25/01346/OUT The Moors, Kidlington

Response to CDC Urban Design Comments, August 2025

Nick Thomas CMLI

6. Land Use Parameter Update

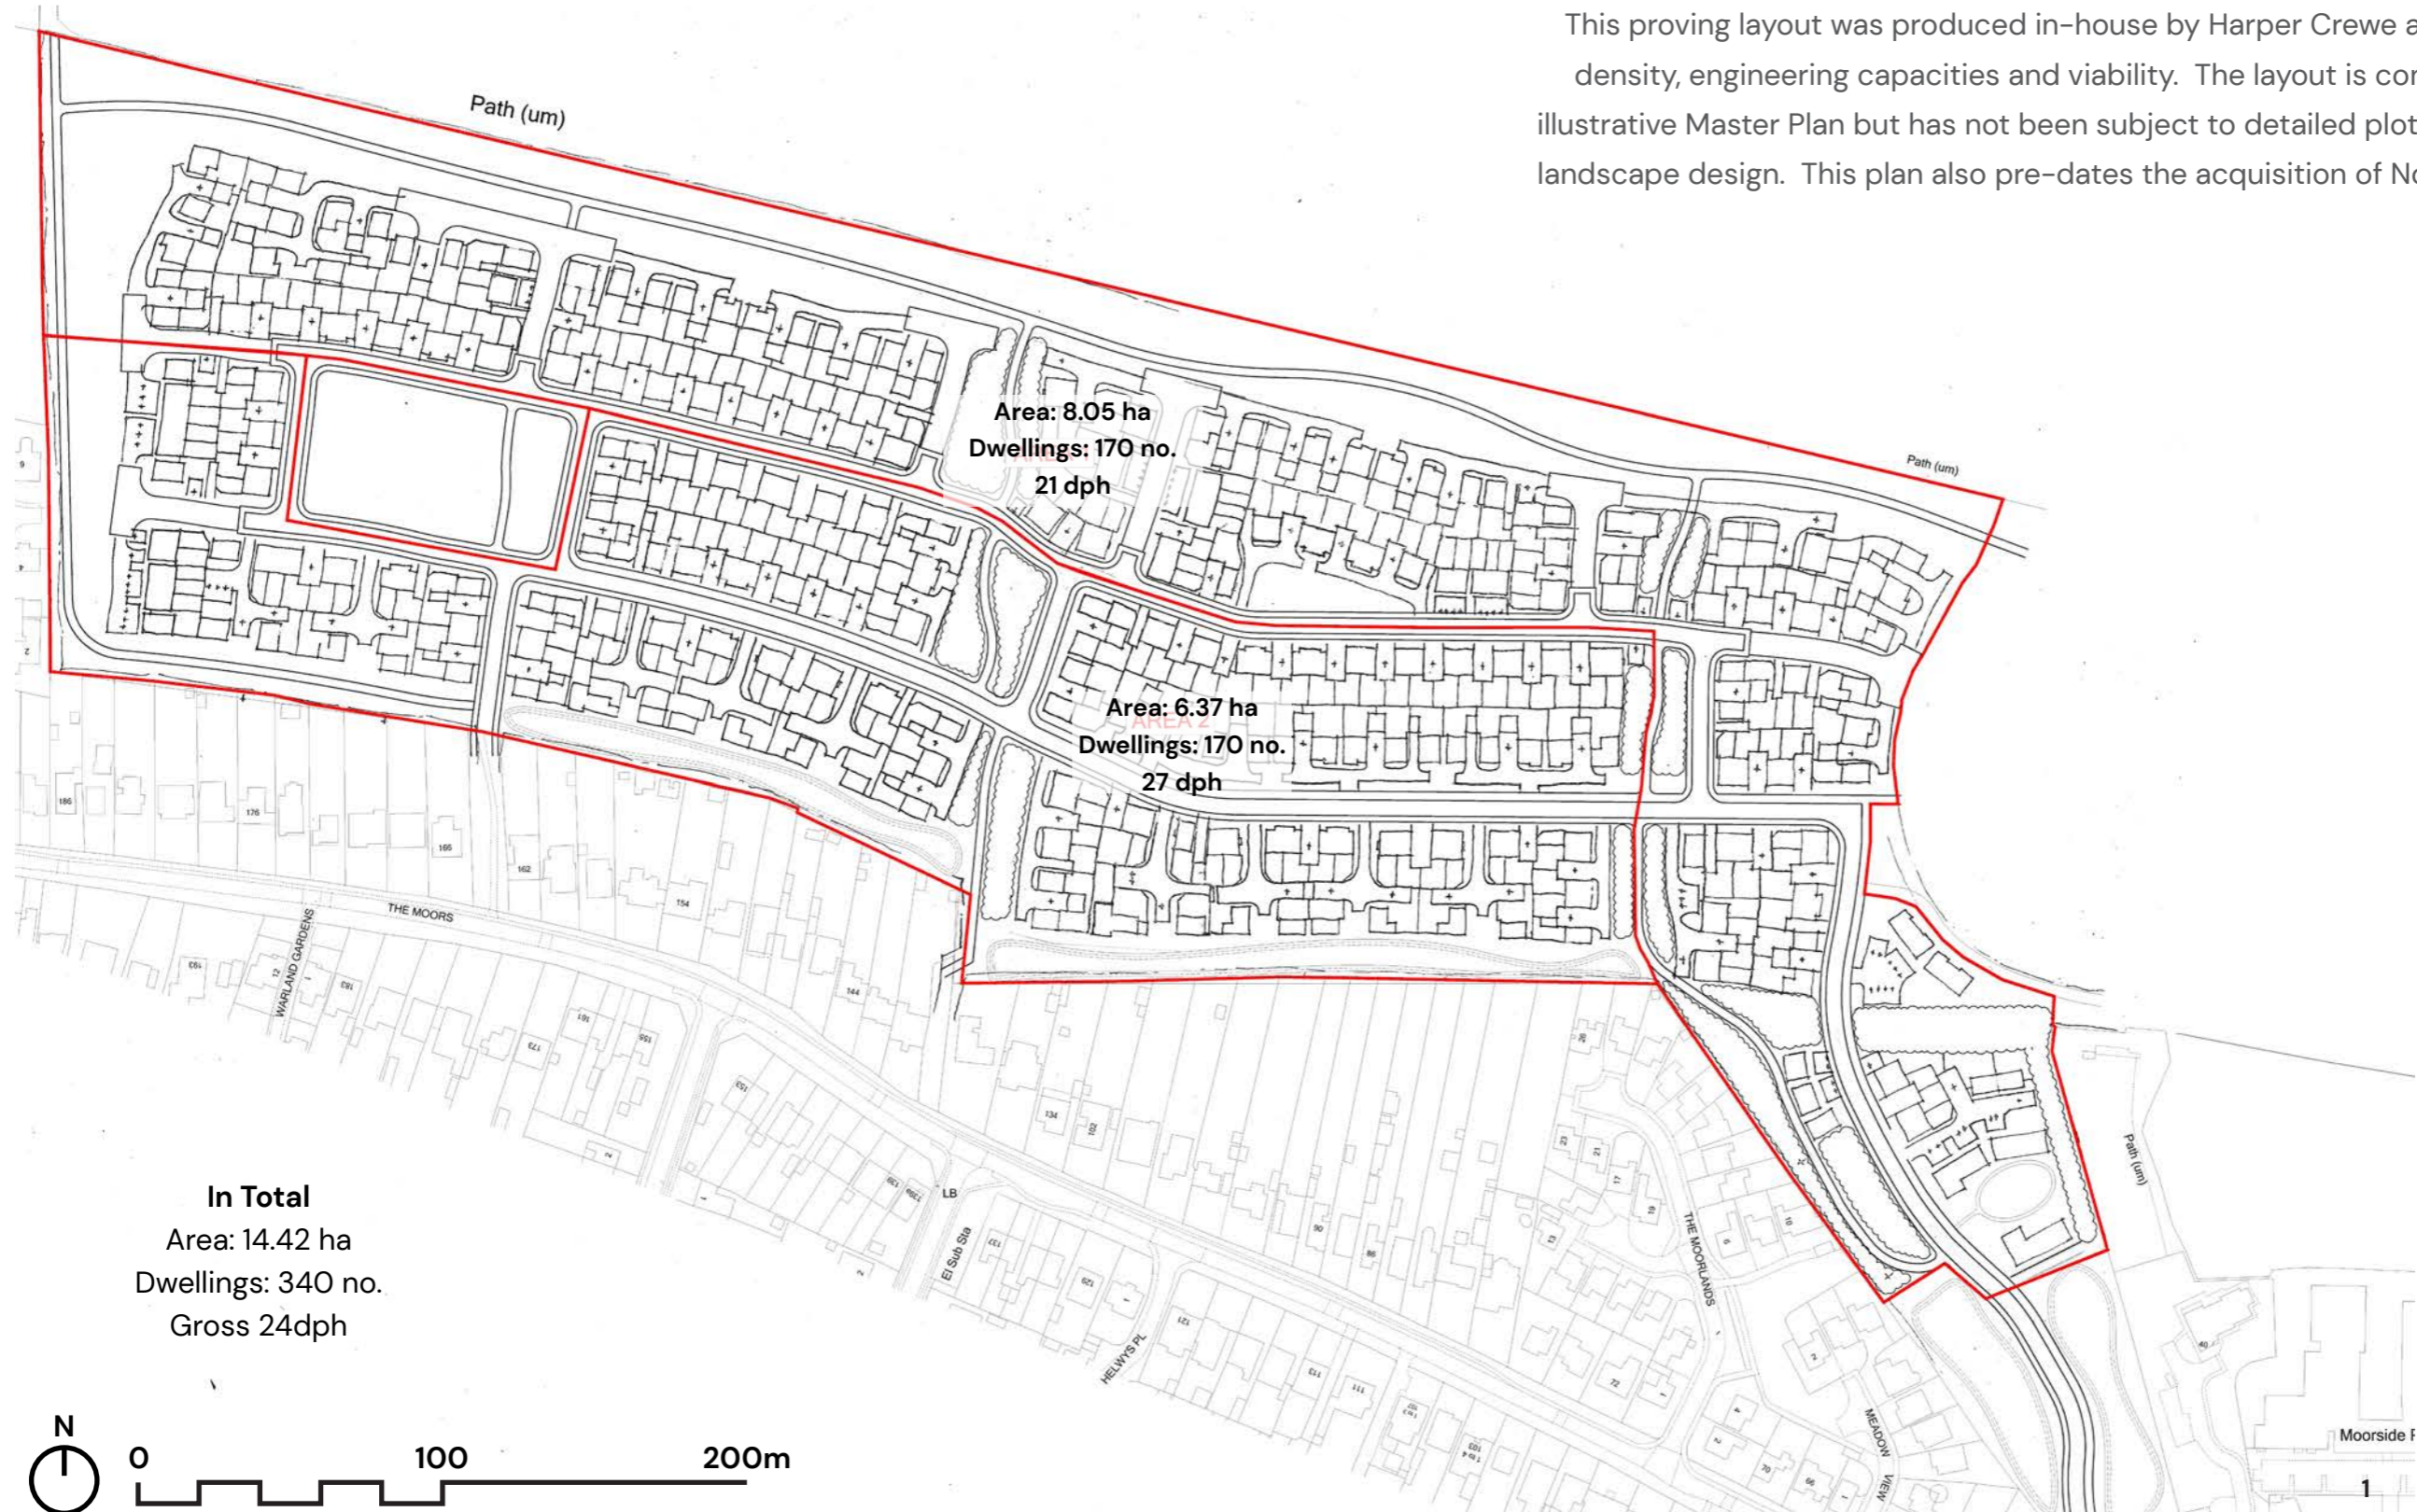
Item	CDC Urban Design Comments Amendments Requested	Applicant Response
1.0	<p>Amend the width of Green Infrastructure to the site's northern edge (Long Way) from 20 metres to 25 metres. This is to ensure the principles shown within the DAS and the illustrative landscape masterplan are deliverable. Note: The Long Way Section on page 106 of the DAS illustrates a 25-metre Green Infrastructure Corridor and the Landscape Masterplan indicates a 27-metre corridor.</p>	<p>We have increased the width of Long Way to 25m wide on the 1360-010 Land Use and Access Parameter Plan to align with the illustrative material presented in the DAS.</p>

3.0	Amend width of the two north-south active transport corridors, which follow the line of existing hedgerow (Middle Green and Cricket Green Character Areas), from the 5 metre nominal width to 16 metres. This is to ensure the principles shown within the DAS and the illustrative landscape masterplan are deliverable (i.e. existing hedge/footpath/conveyancing swale and tree planting). Note: annotation to the Middle Green corridor on page 117 of the DAS denotes a 16-meter corridor and the Landscape Masterplan indicates a 25-meter corridor.	For clarity, we have increased the north-south active travel corridors to 16m wide on the 1360-010 Land Use and Access Parameter Plan as suggested and to align with the illustrative material presented in the DAS.
